Waterbury Filing Nos. 1 and 2  
Traffic Impact Analysis  
(LSC #204220)  
September 28, 2021

LSC Responses to  
EPC TIS Redline  
Comments<sup>1</sup>

# LSC Responses to TIS Redline Comments

WATERBURY FILING NO. 1 & 2
CONSTRUCTION SET
ROUNDABOUT FASTEST PATH

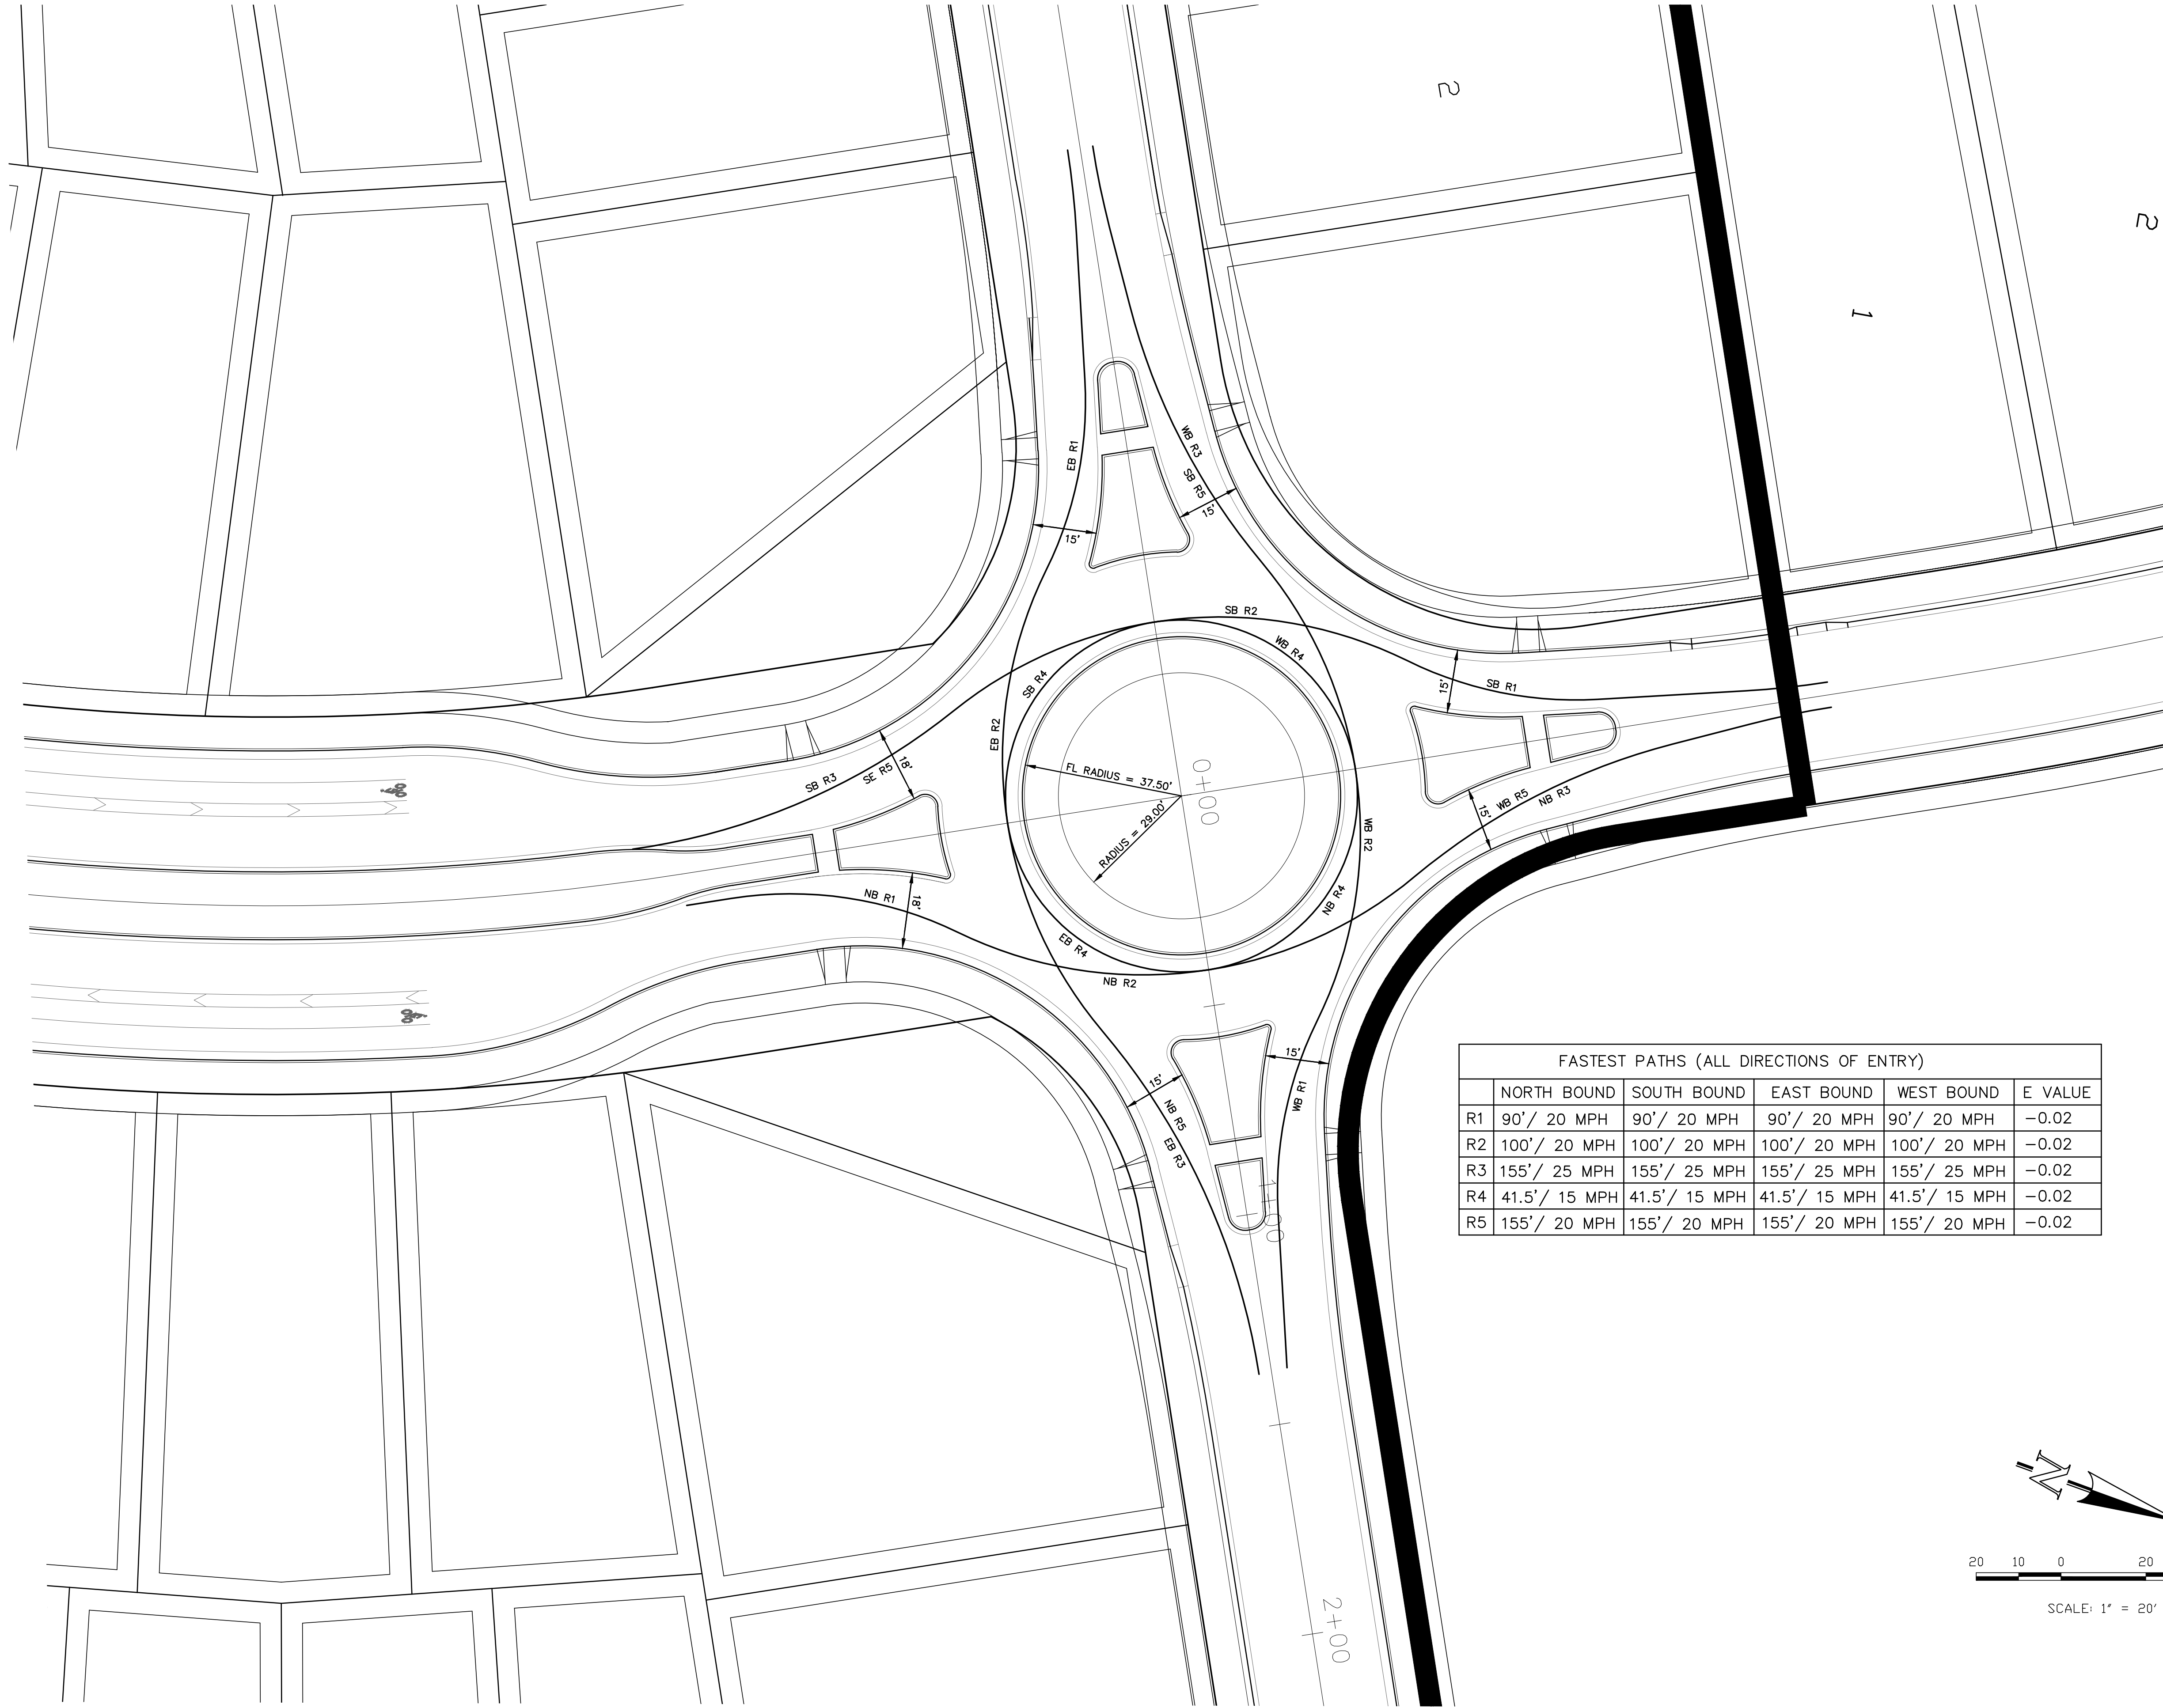
[Provide preliminary roundabout design for Saybrook/Sunken Meadow in this or a separate report](#)

LSC Response: This is included in the updated TIS as requested. Also, please refer to LSC response to the comment letter comment.
